ENG-PUDSP21006-R1-PUDSP.pdf Markup Summary

GEOLOGY & SOILS

**FINAL PLANTING PLAN**

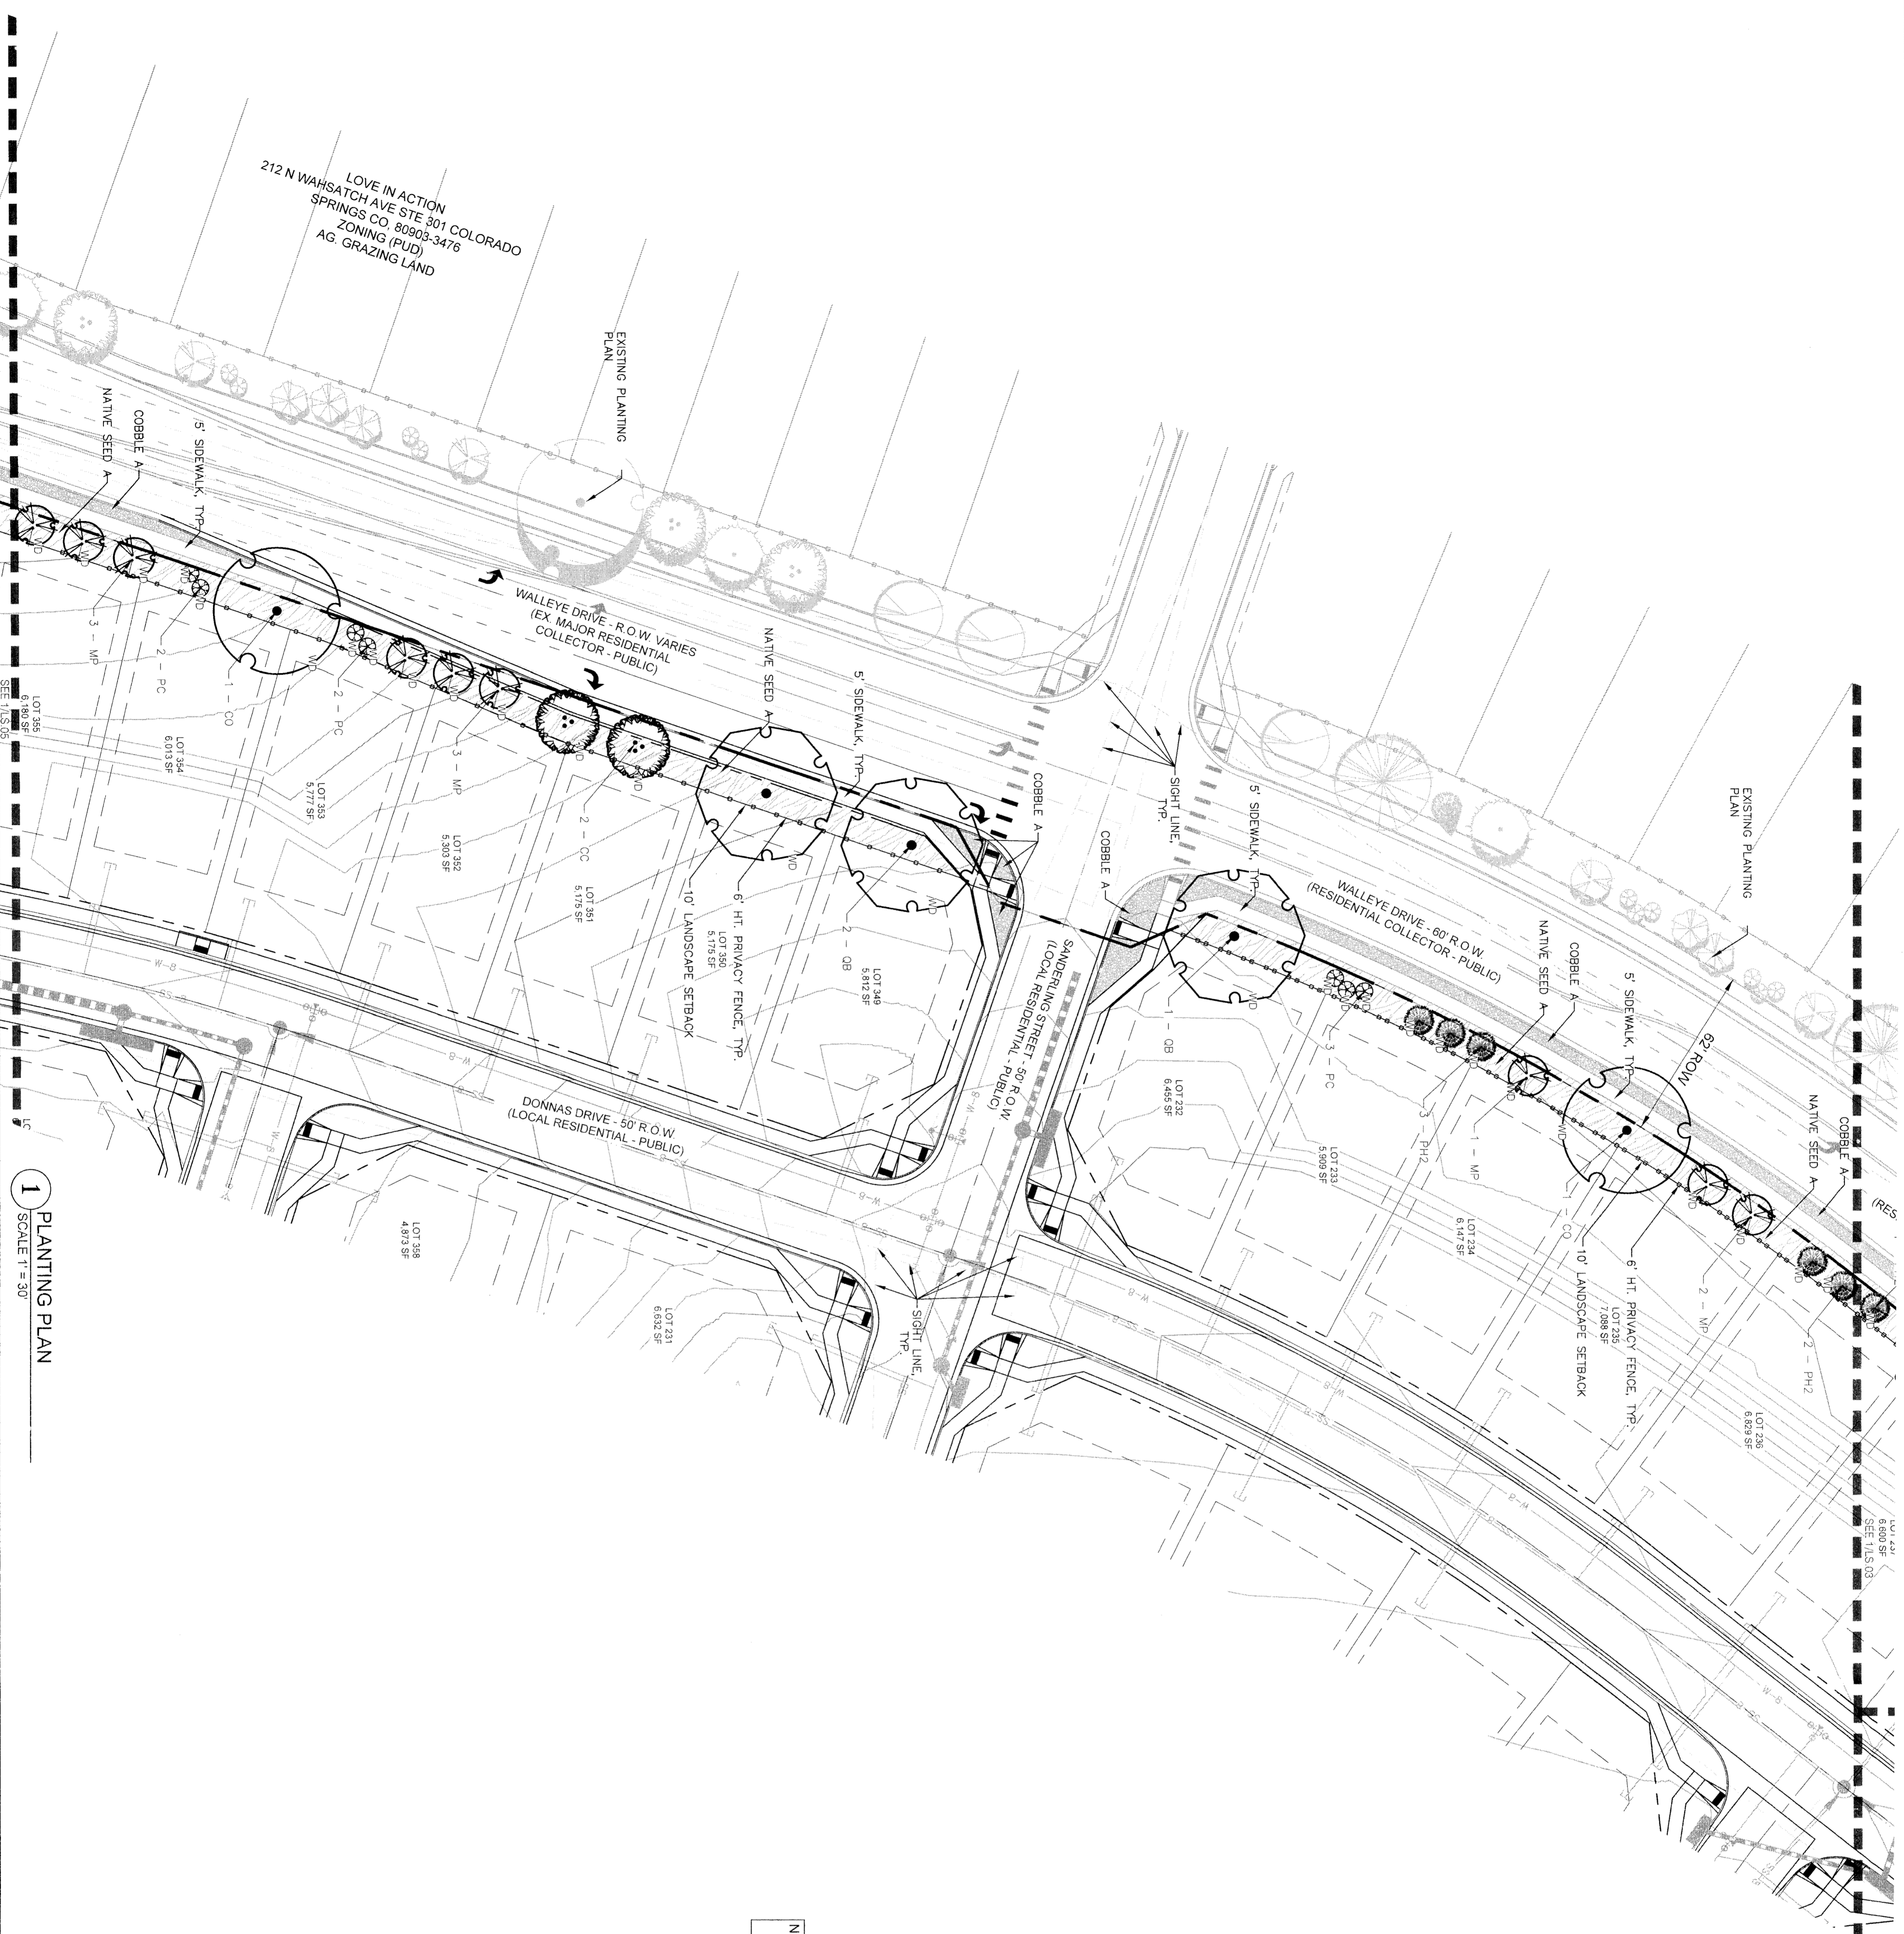
Add sight distance to landscape plan stop controlled intersections please, verify plantings are less than 3.5' and more than 8' canopy

**1** PLANTING PLAN  
SCALE 1" = 30'

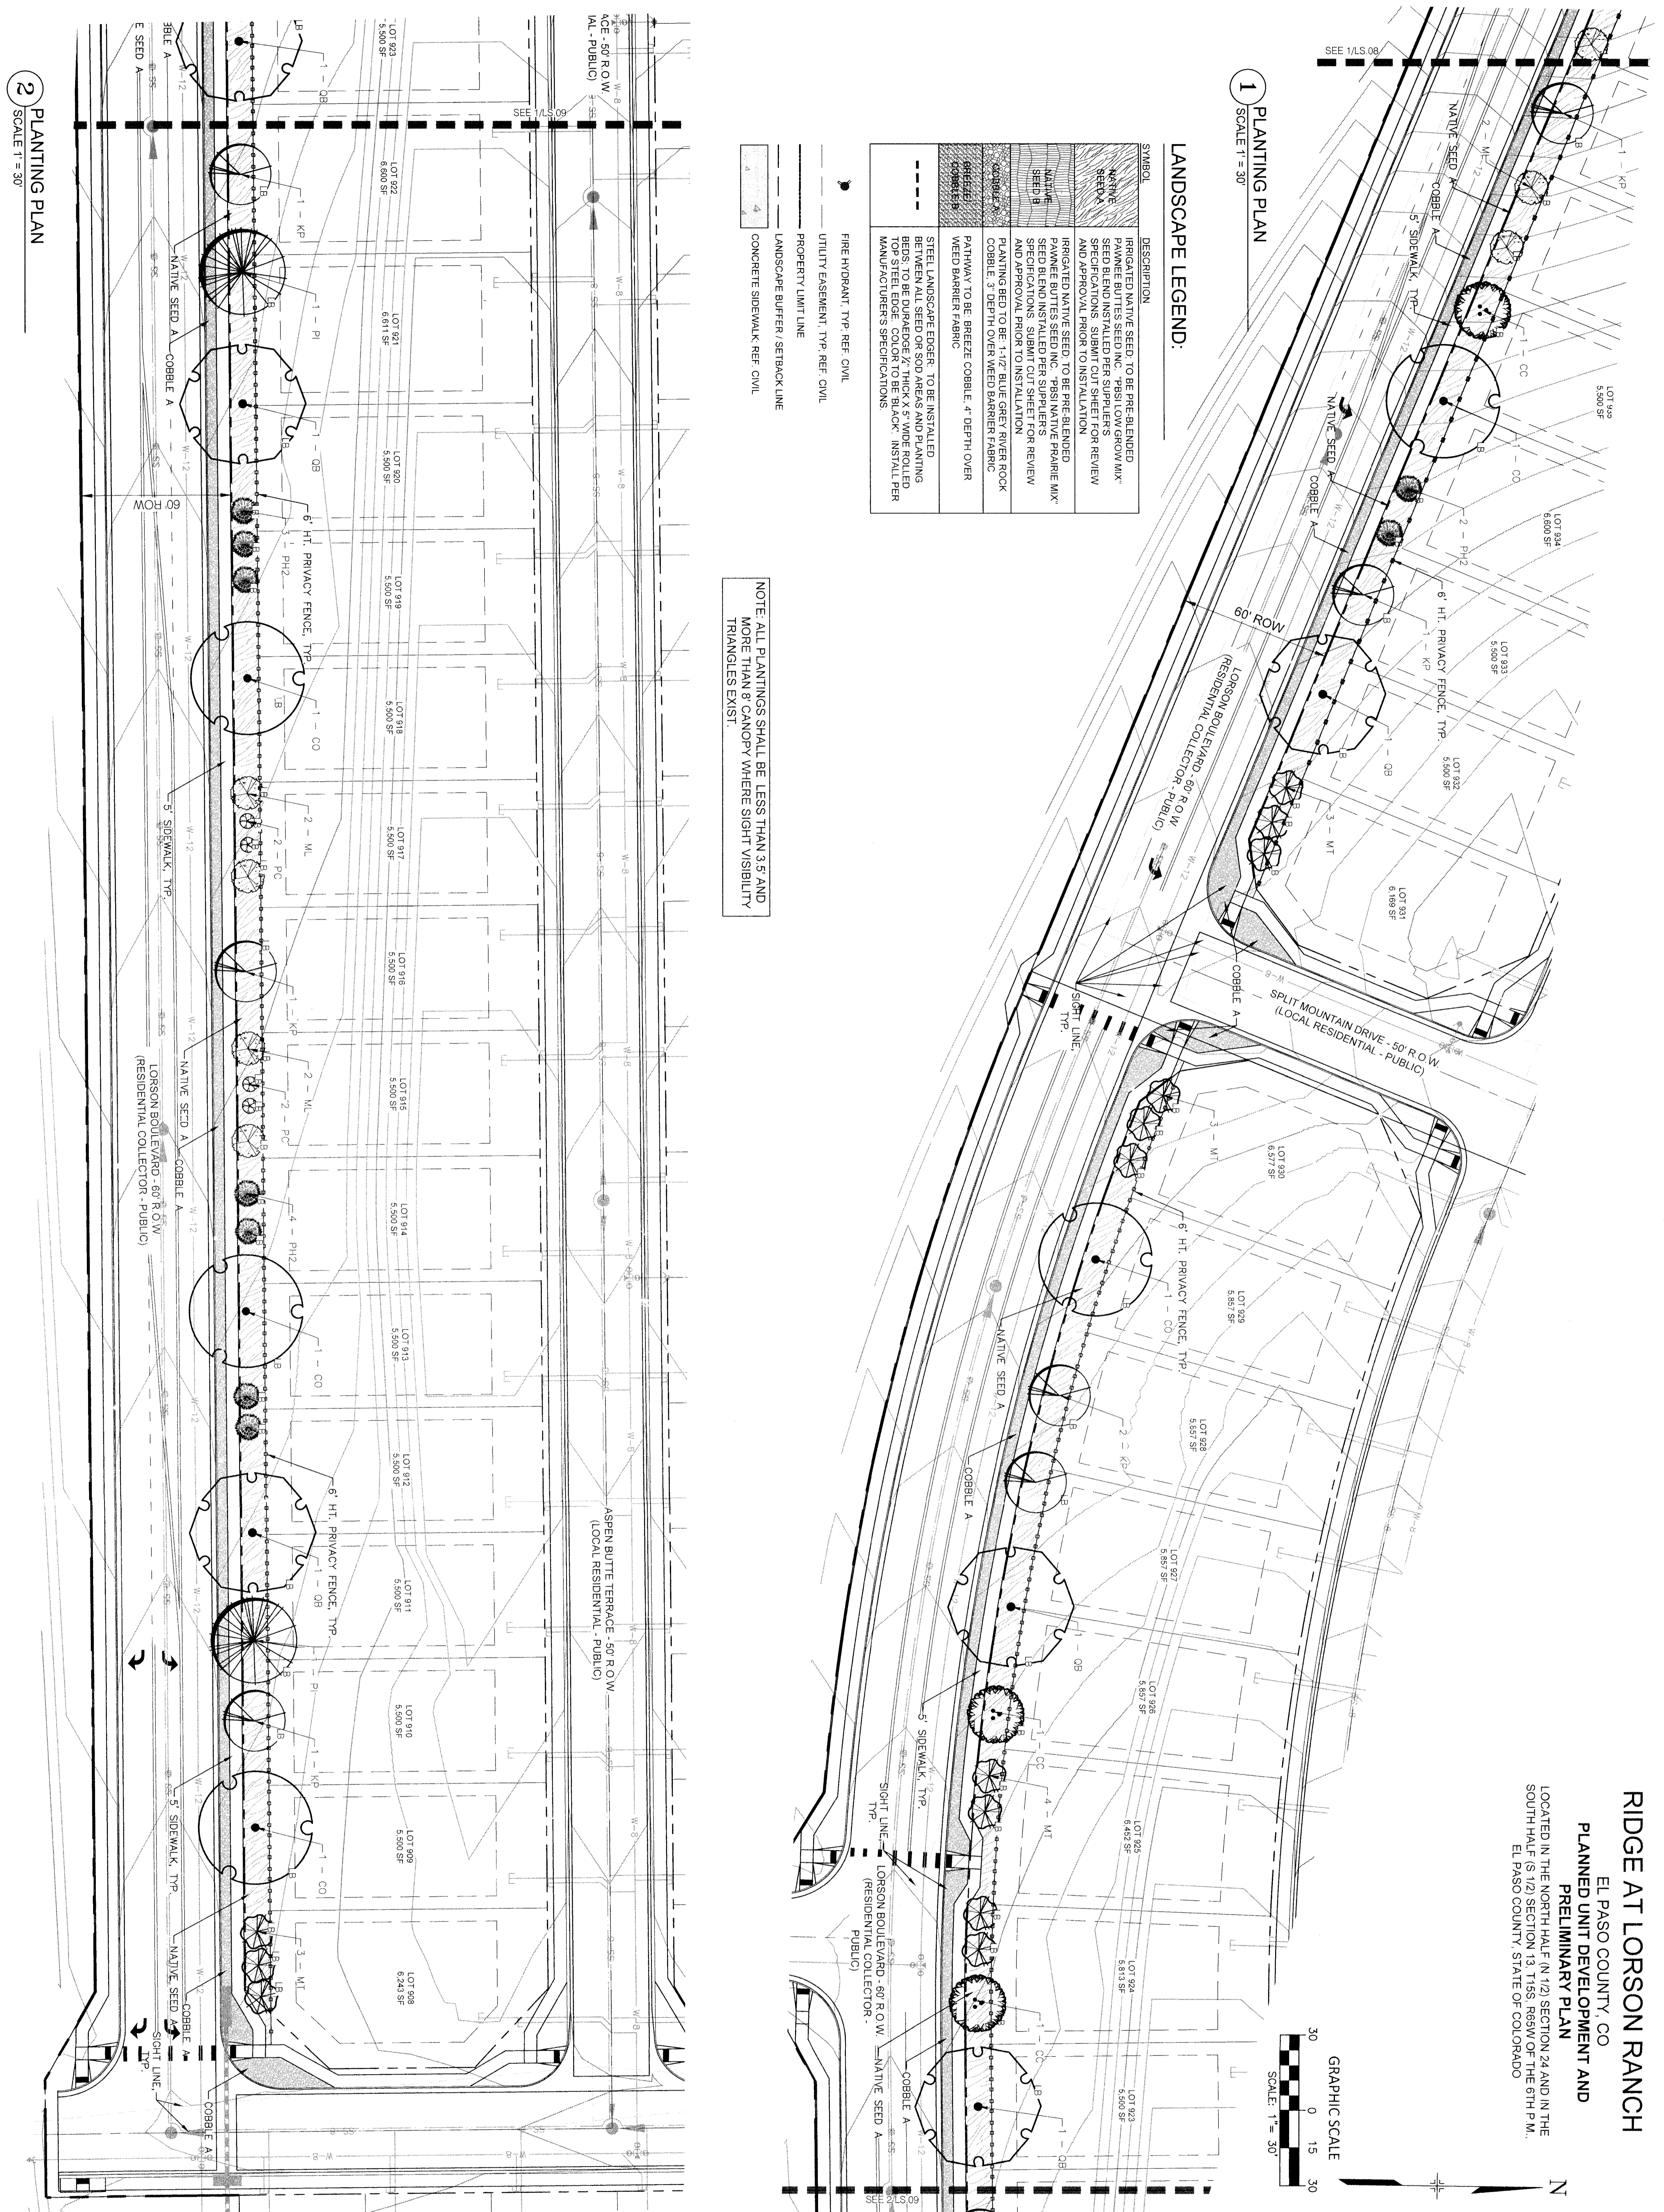
Add all sight distance triangles to endure plantings are under 36" or canopy is over 8 feet
